SSD 10375 (Pitt St North) Stage 2 Development Application – Advice on EIS

Thank you for your correspondence dated 16 July 2020 seeking the City of Sydney's (the 'City's') comments on the above detailed design for the Pitt Street North OSD at 175-183 Castlereagh St, Sydney.

3.5 level 11 - detail plan

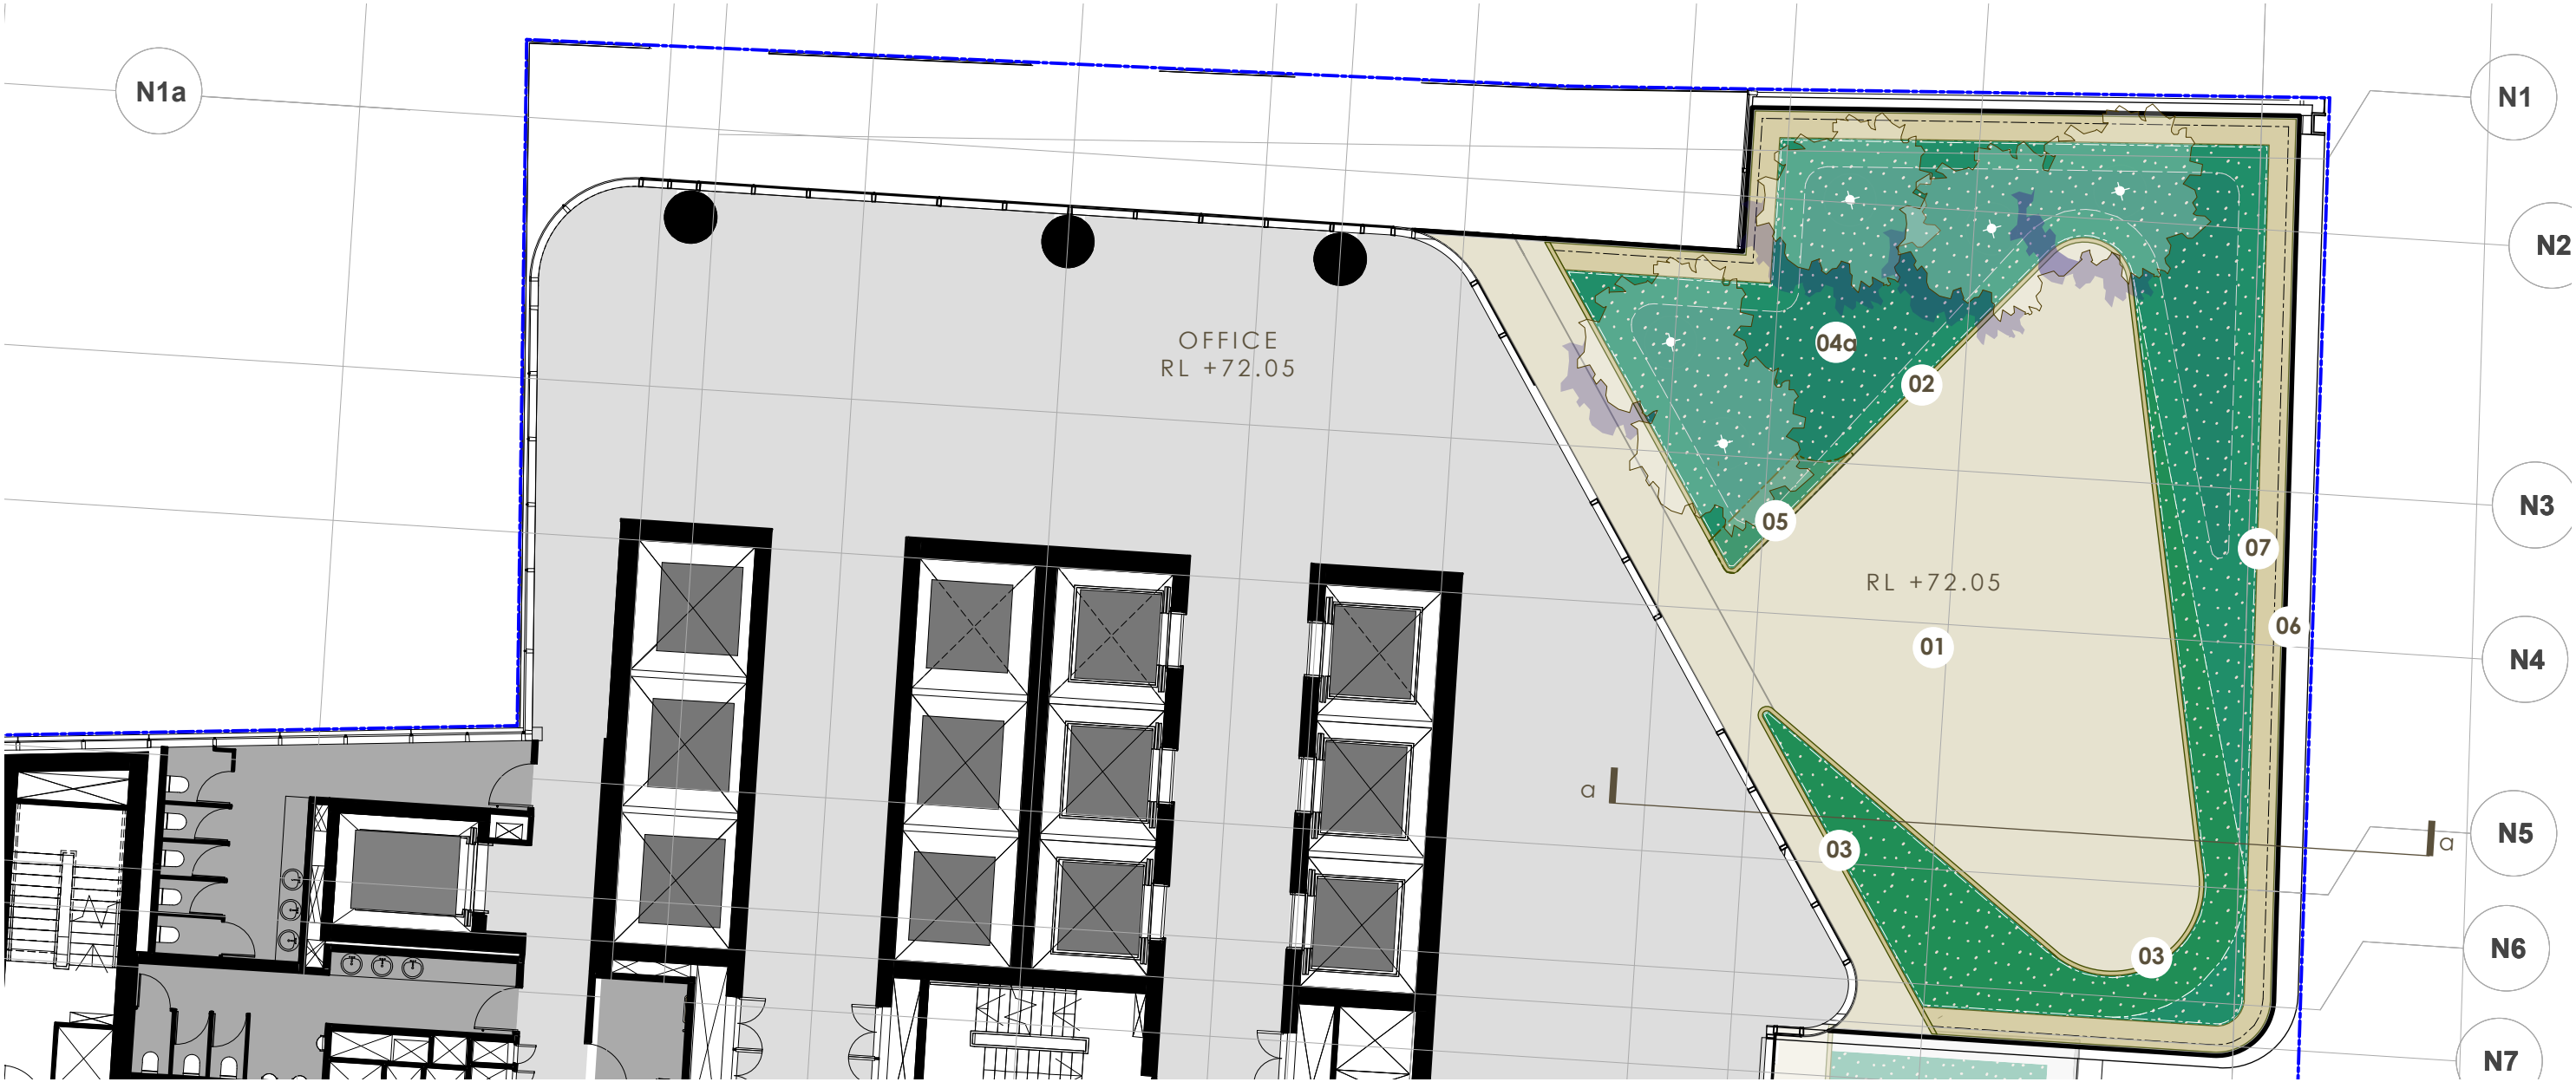
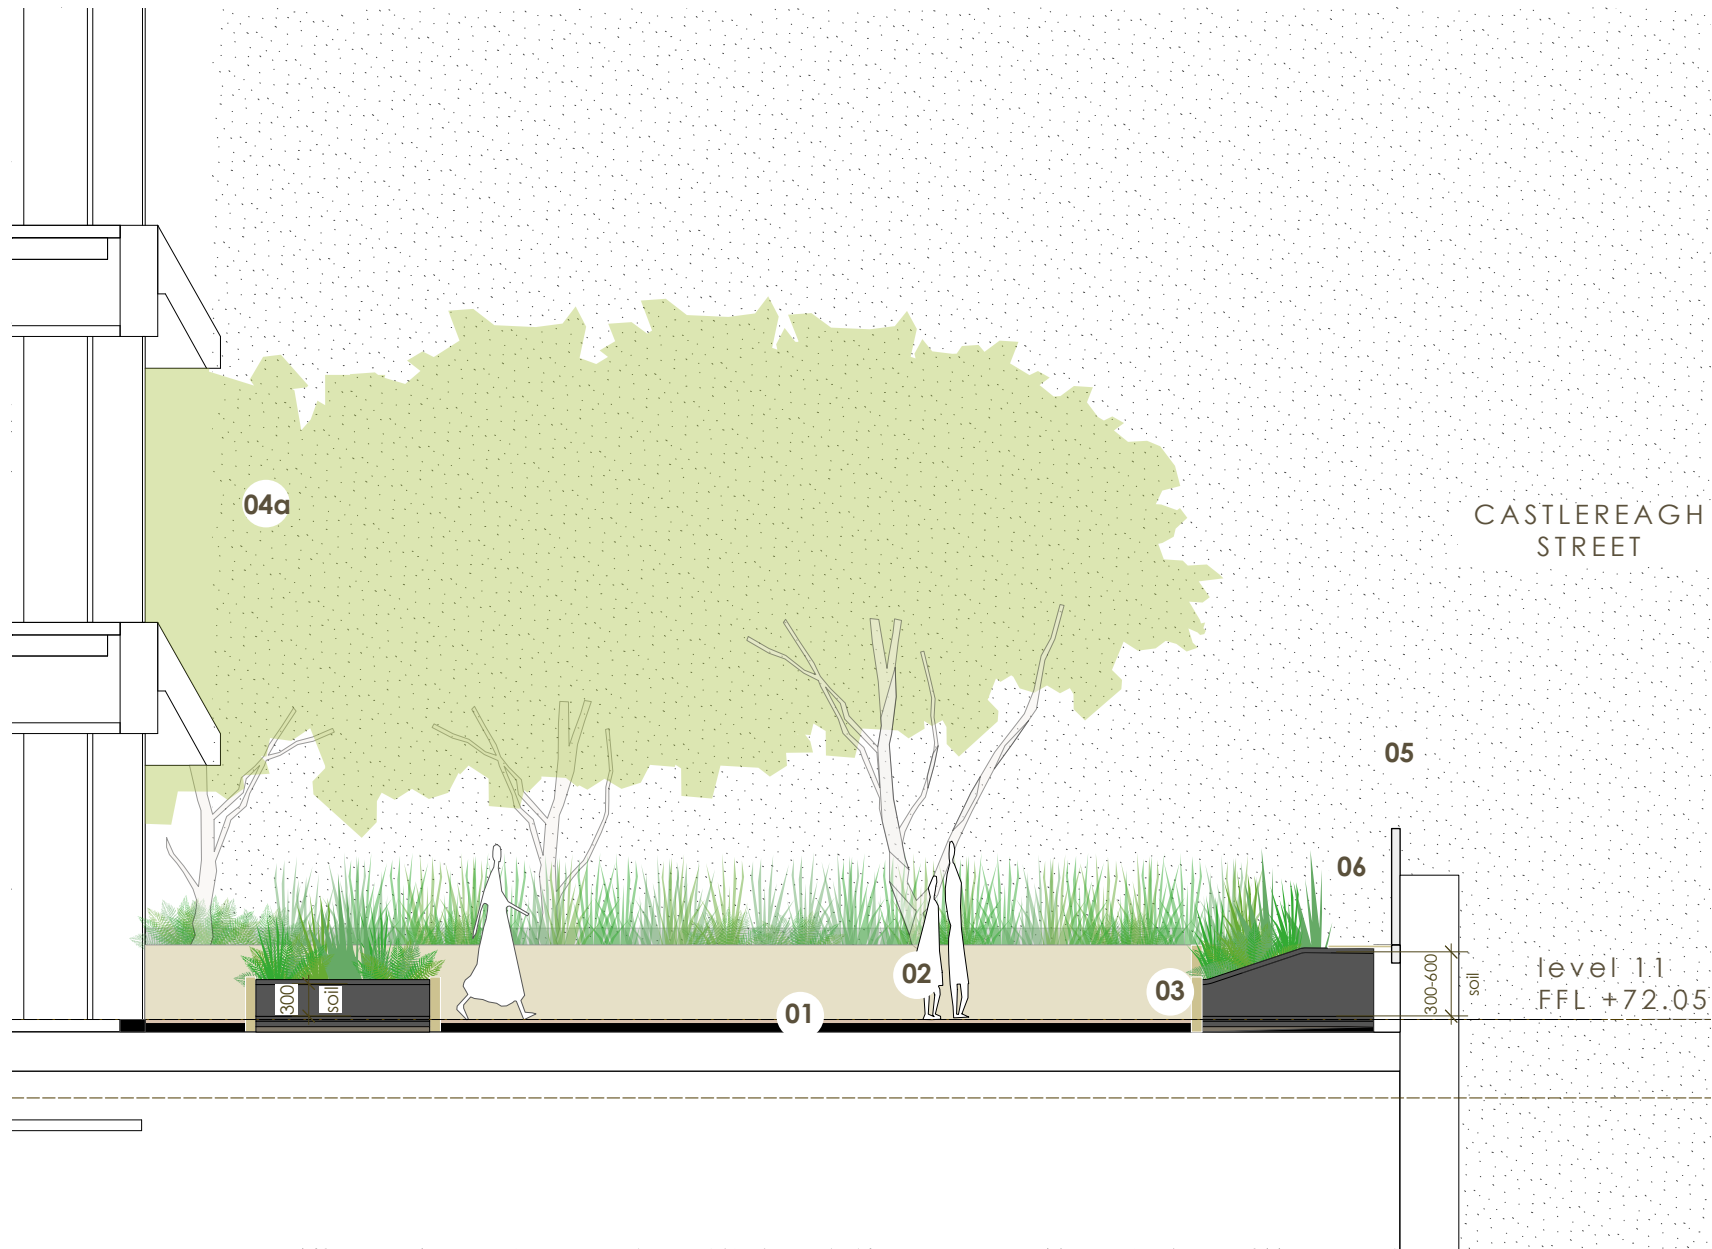
- (ii) Submit amended plans coordinated with wind recommendations;
 - (iii) Amend Level 10-11 tree planters to provide minimum 1metre soil depth and comply with the *Sydney Landscape Code Volume 2*;

- (iv) Substitute small with a mix of medium sized tree species and add additional trees to meet the wind report recommendations on both levels;
 - (v) Submit details for climbing frame and planter for green screens to service areas.
